## Meeting note

<b>Project name</b>	M3 Junction 9 Improvement
<b>File reference</b>	TR010055
<b>Status</b>	<b>Final</b>
<b>Author</b>	The Planning Inspectorate
<b>Date</b>	08 December 2021
<b>Meeting with</b>	National Highways
<b>Venue</b>	Microsoft Teams
<b>Meeting objectives</b>	Draft documents review
<b>Circulation</b>	All attendees

**M3 JUNCTION 9**

**Section 51 advice regarding draft application documents submitted by NATIONAL HIGHWAYS**

Insert 3.3 – Option 16A

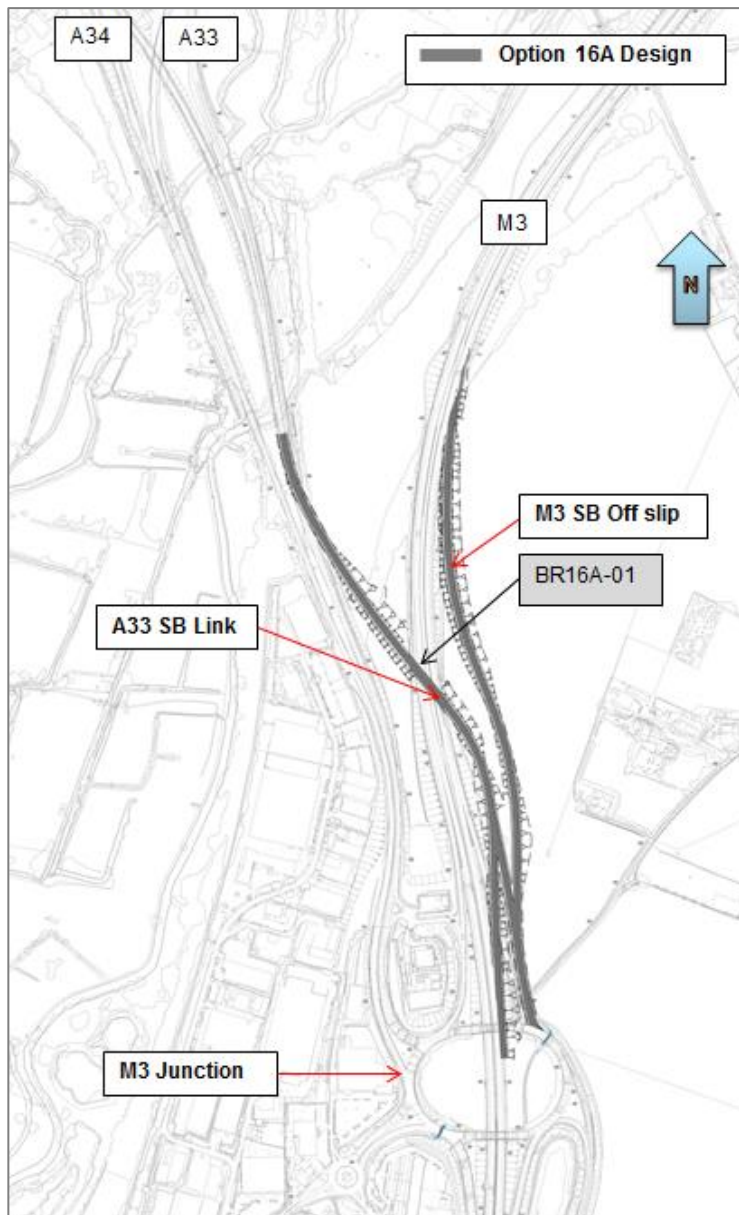
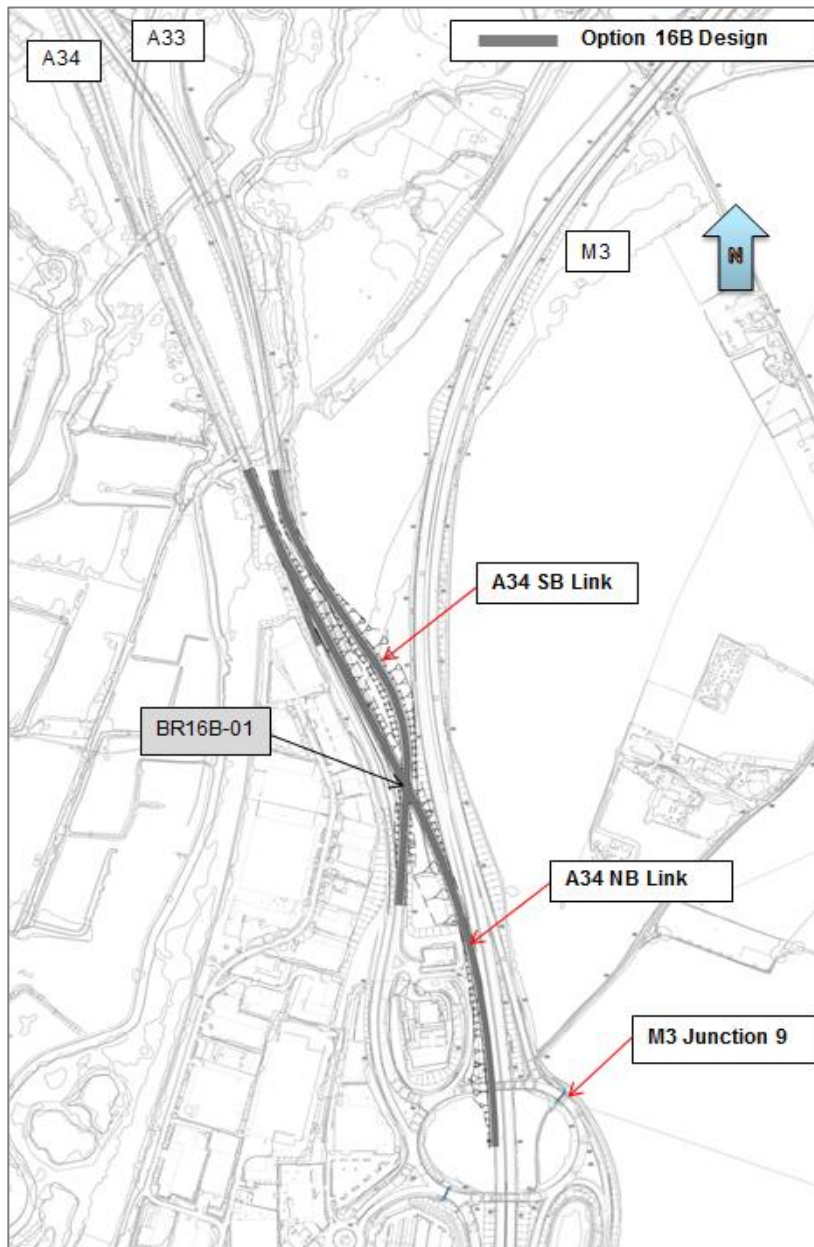
<b>30.</b>	<b>3.2.4</b>	Figures depicting Options 16A and 16B are presented, however Option 16C, a variation of 16A and which replaced it, is not depicted. Suggest a figure is included.
<b>31.</b>	<b>3.5.5 and fourth bullet</b>	It is stated that there would be a moderate adverse construction effect in relation to road drainage and the water environment for Options 14, 16A and 16B, however a large adverse effect is identified in Table 3-1 above.
<b>32.</b>	<b>3.6.2 &amp; 3.6.3</b>	Reference is made to ‘the consultation brochure’, however no cross-reference or hyperlink (notwithstanding PINS decision on whether use of hyperlinks is acceptable) is provided to that document.
<b>33.</b>	<b>3.11.5</b>	‘Stage 2’ and ‘Stage 3’ are first used here and are not defined in this chapter.  Should the reference to ‘Option 14’ in the last line be to ‘Option 14C’?
